ENG-PUDSP21010-R3-CDs-Channel.pdf Markup Summary

Comments remain cursory due to the need for the design report, additional grading, complete details and how this ties in to the ultimate subdivision design.

Engineering Review
 04/20/2022 4:17:19 PM
 dsdrice
 JctRisks@engr.com
 (714) 933-7877
 EPC Planning & Community
 Development Department

SHEET NO.
GR6 09

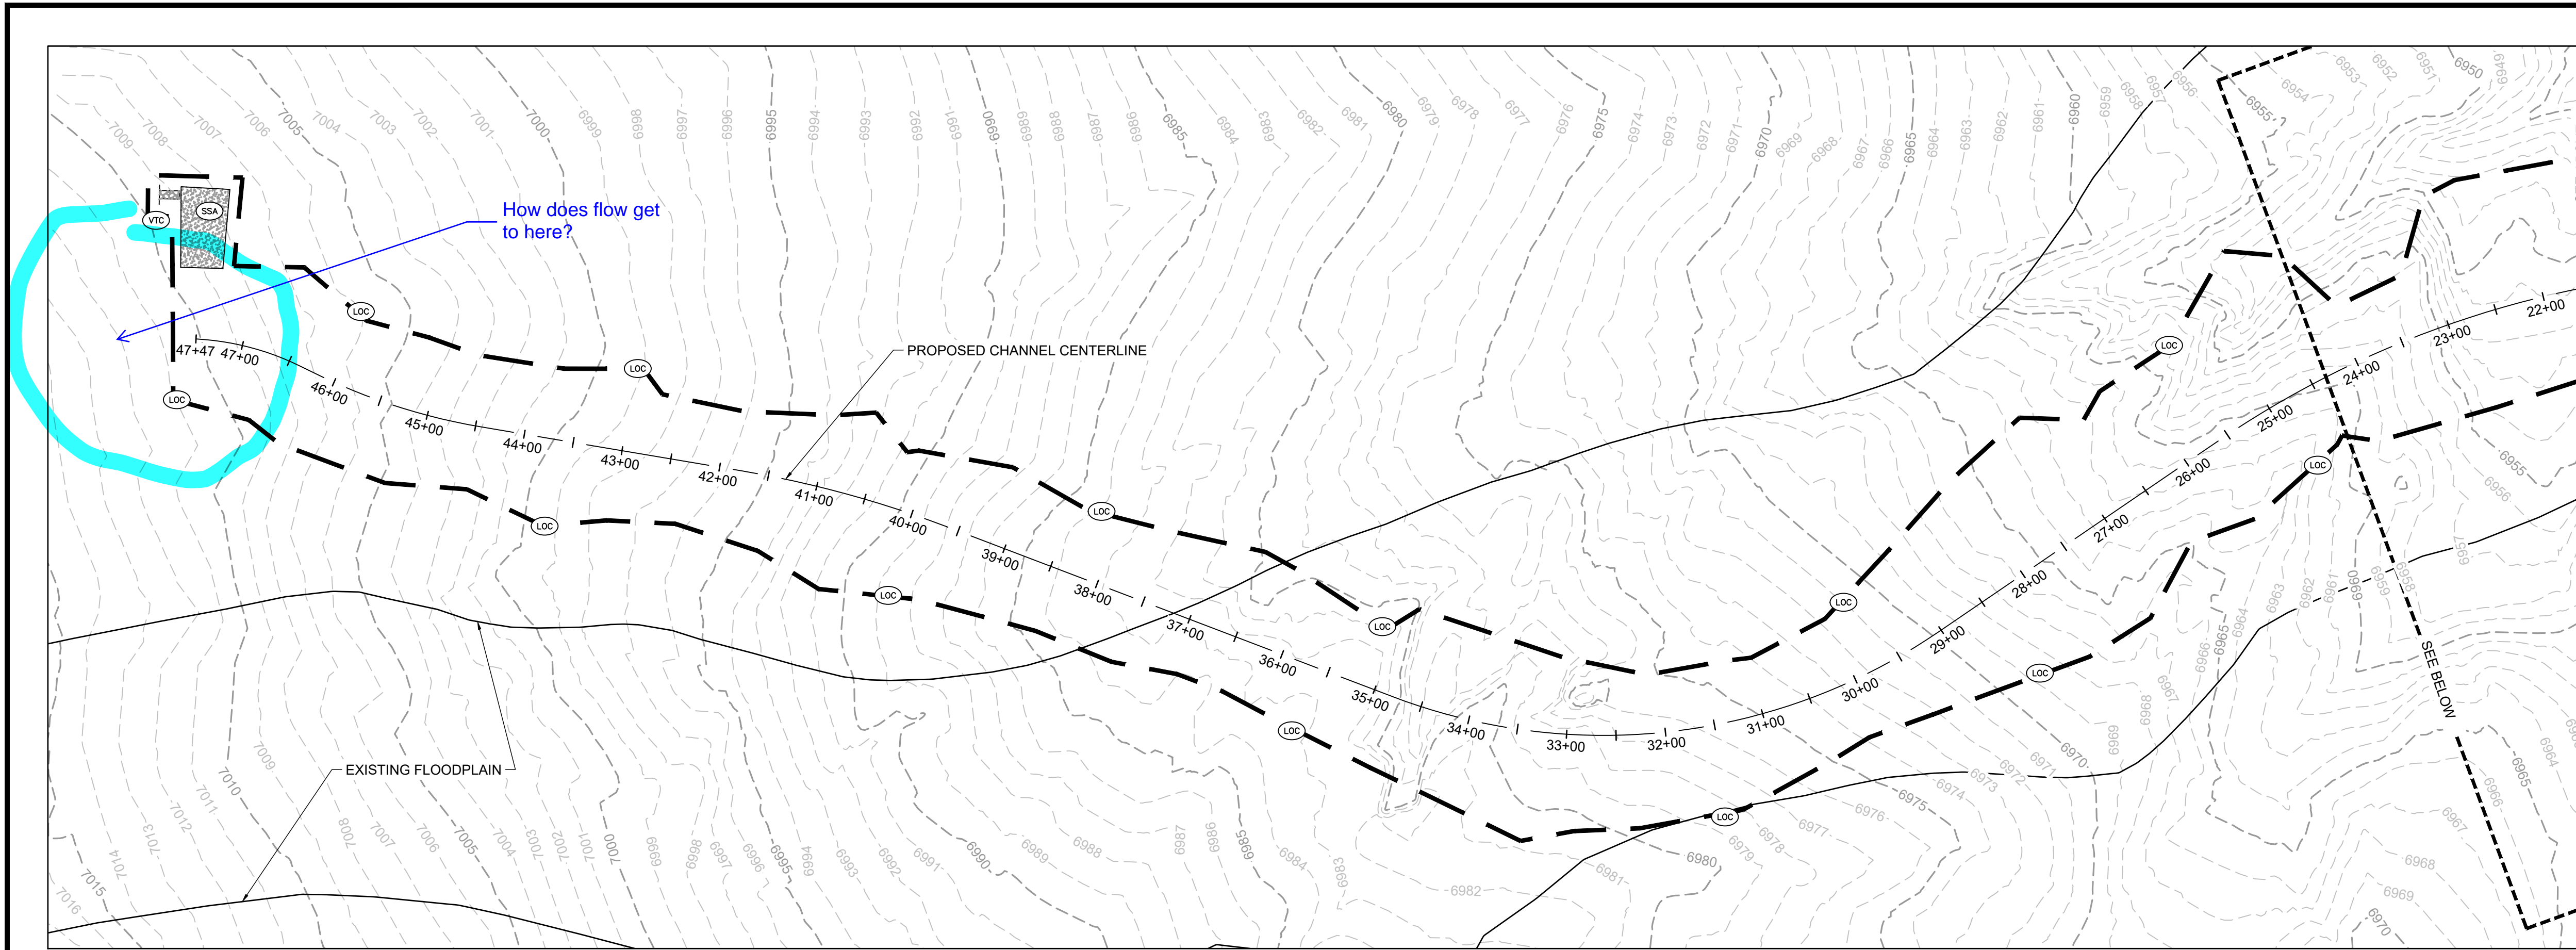
Label proposed contours

show the culverts and grading

SHEET NO.
GR4 07

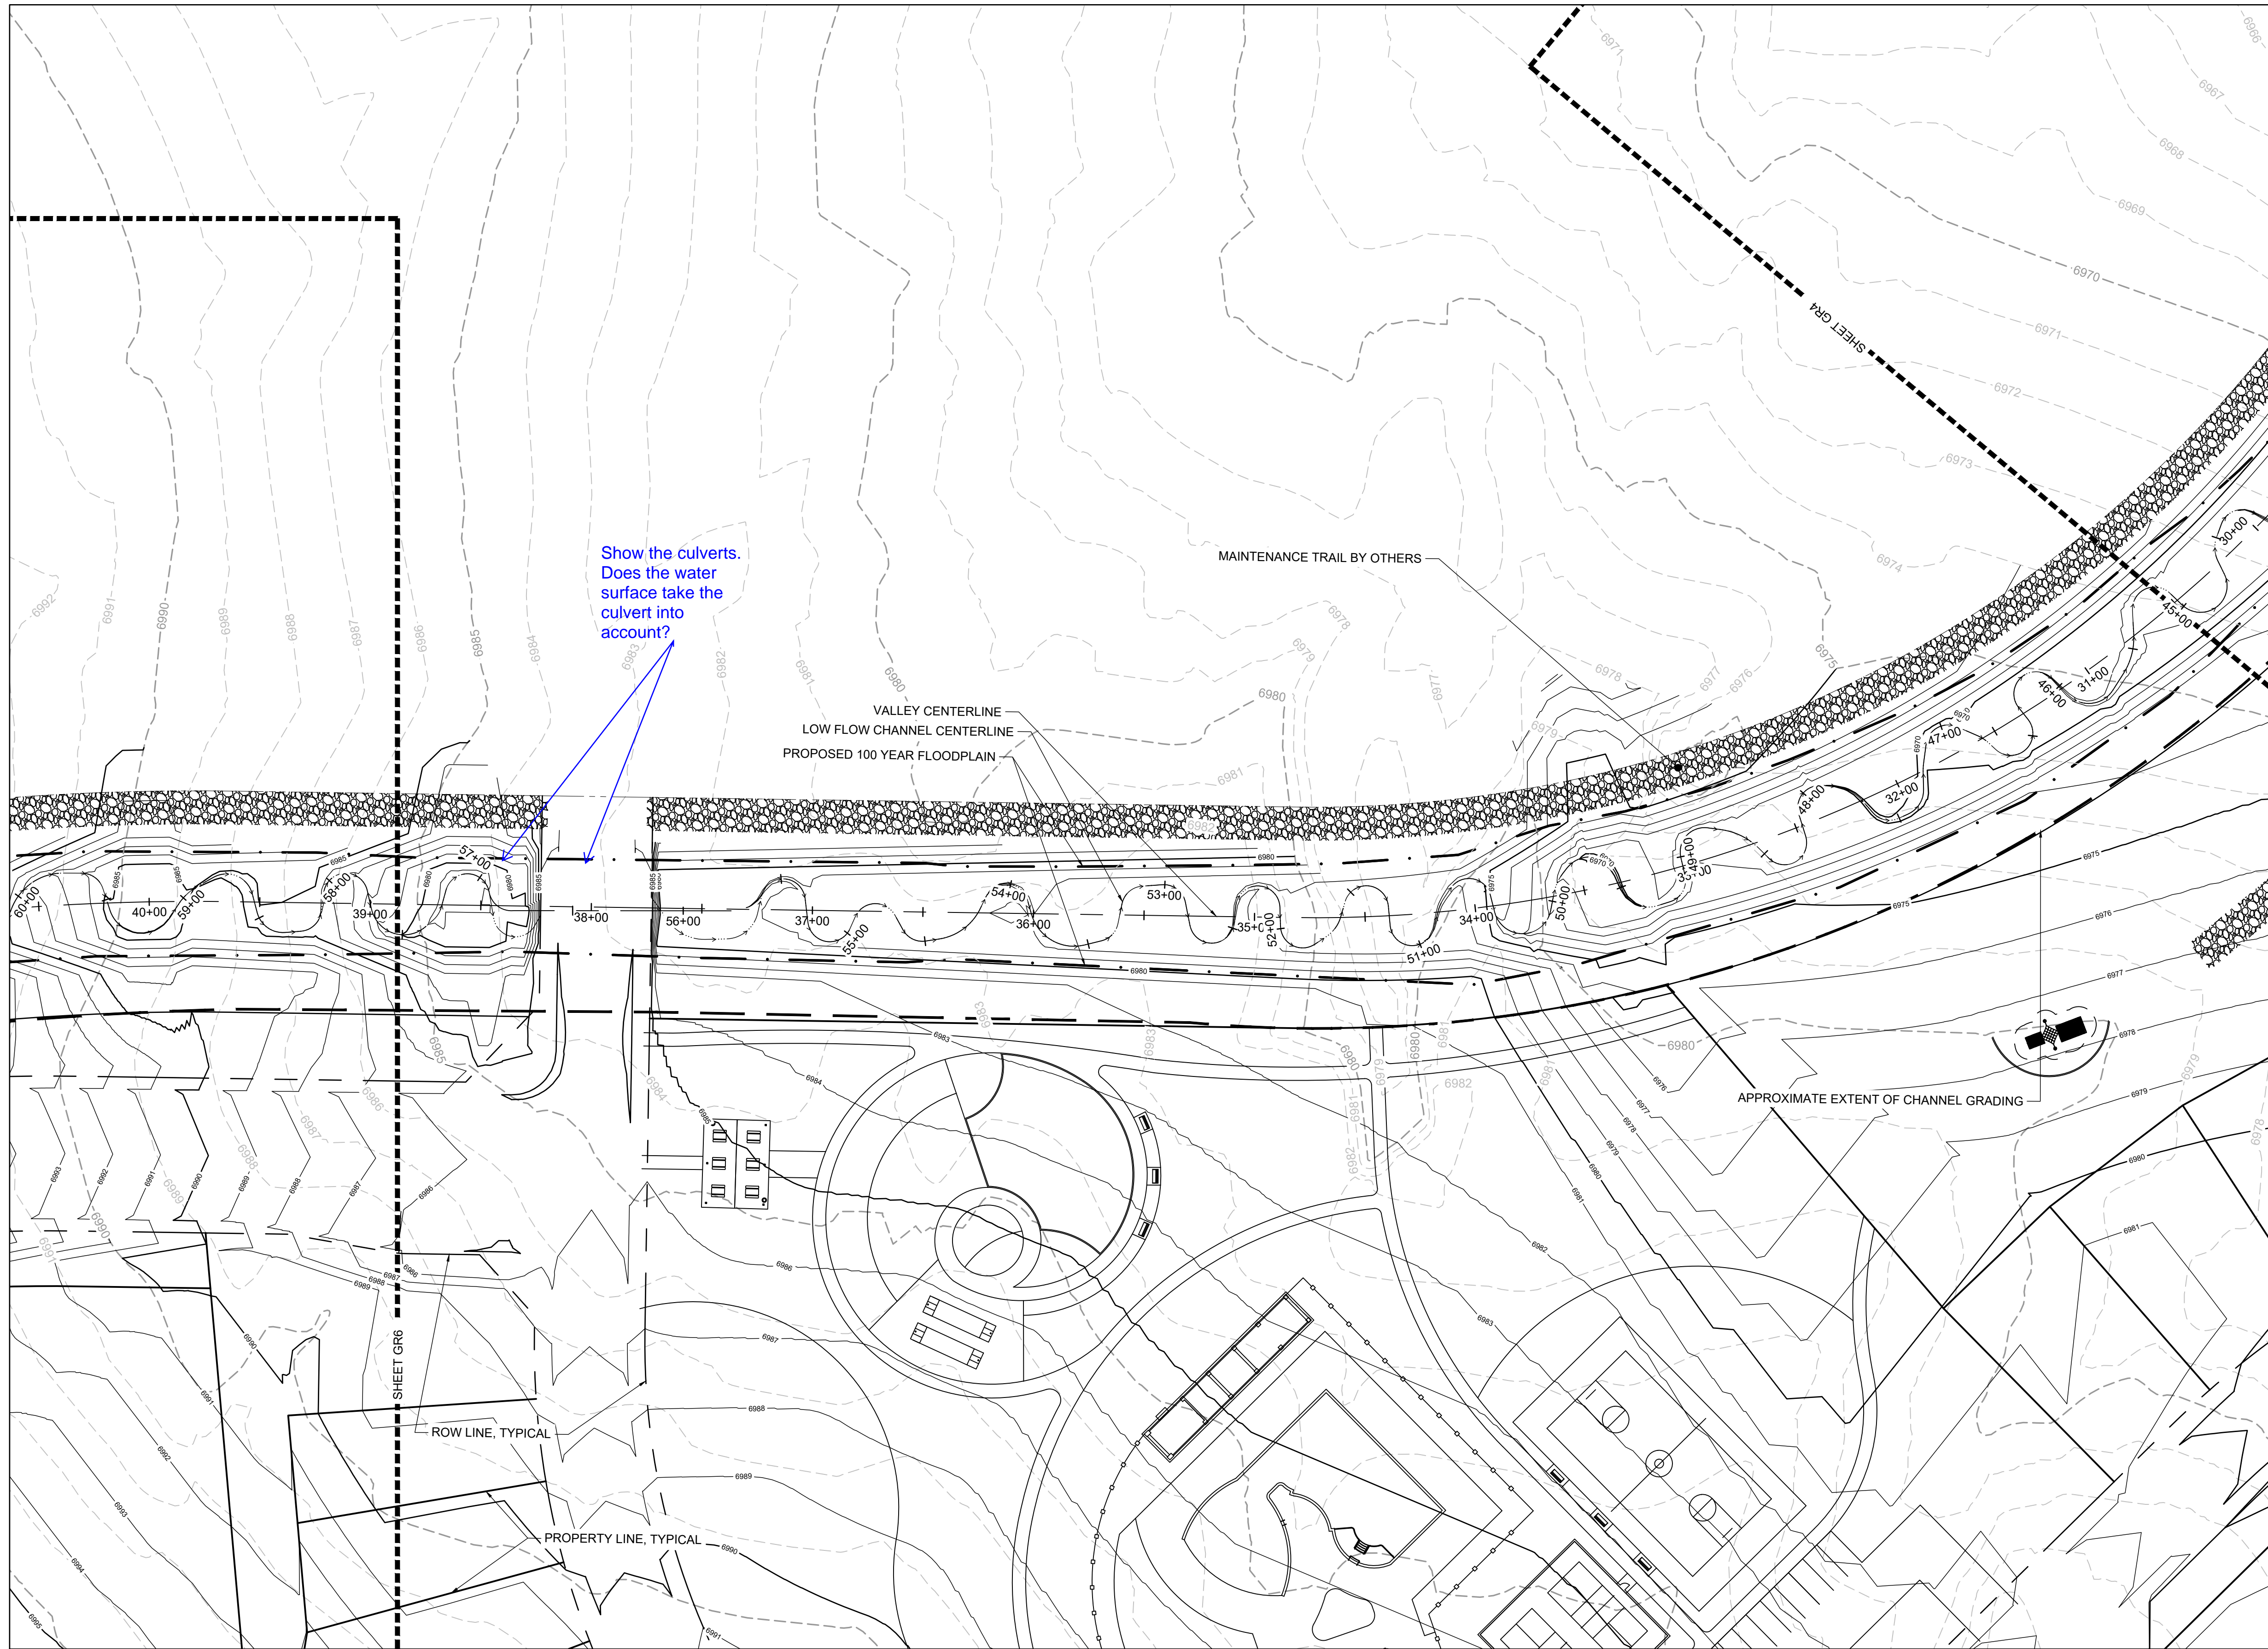
Berms/levees cannot be used to protect development

Subject: Callout (see cross-section redline)
Page Index: 7
Date: 4/20/2022 4:19:13 PM
Author: dsdrice
Color: ■
Layer:
Space:
Page Label: [7] 07 Channel B Grading

SHEET NO.
GR7 10

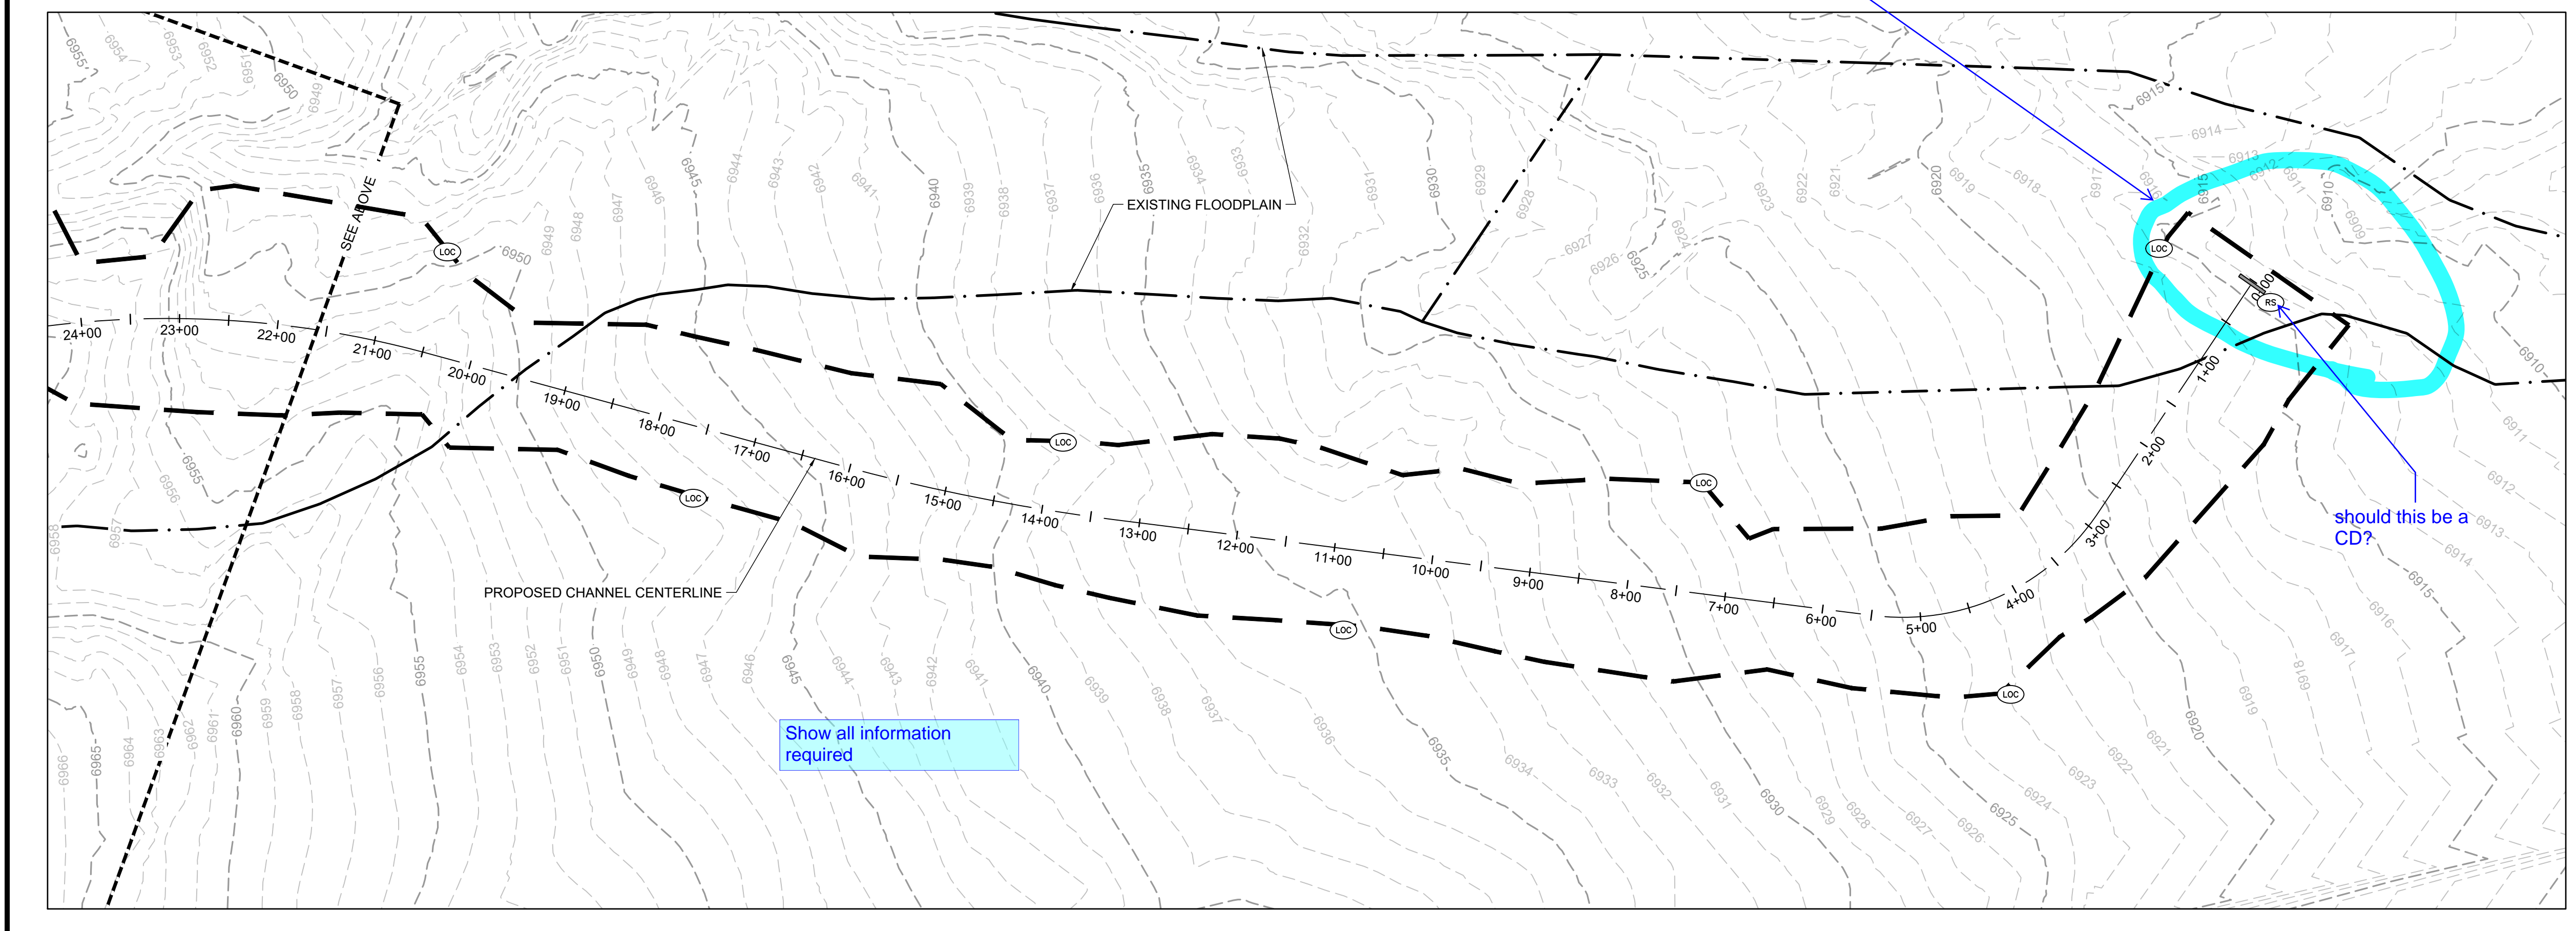
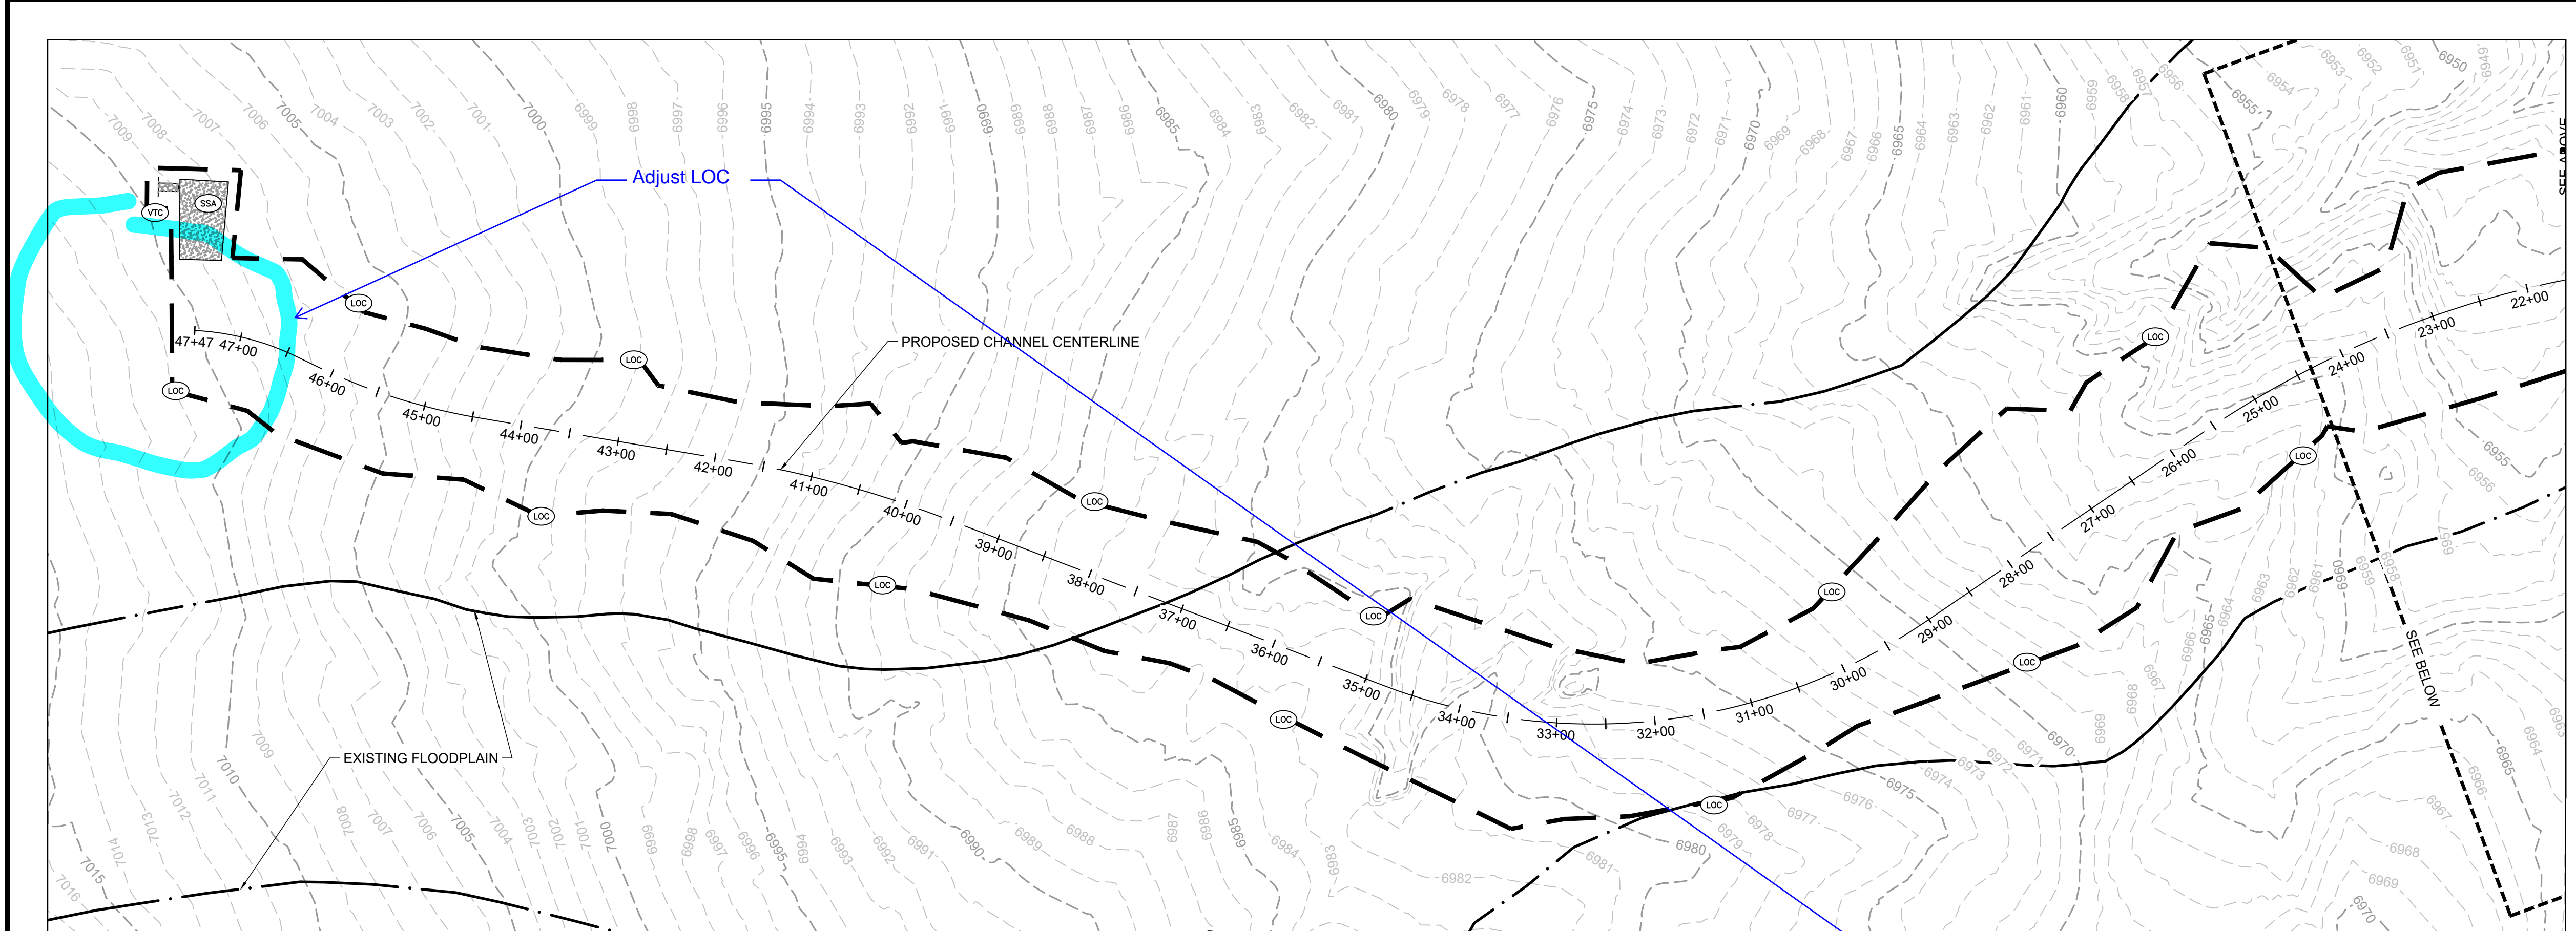
Show existing floodplain, existing and proposed ROW, necessary easements/proposed property lines, label roads (include all necessary information)...

Provide details on how this area will drain
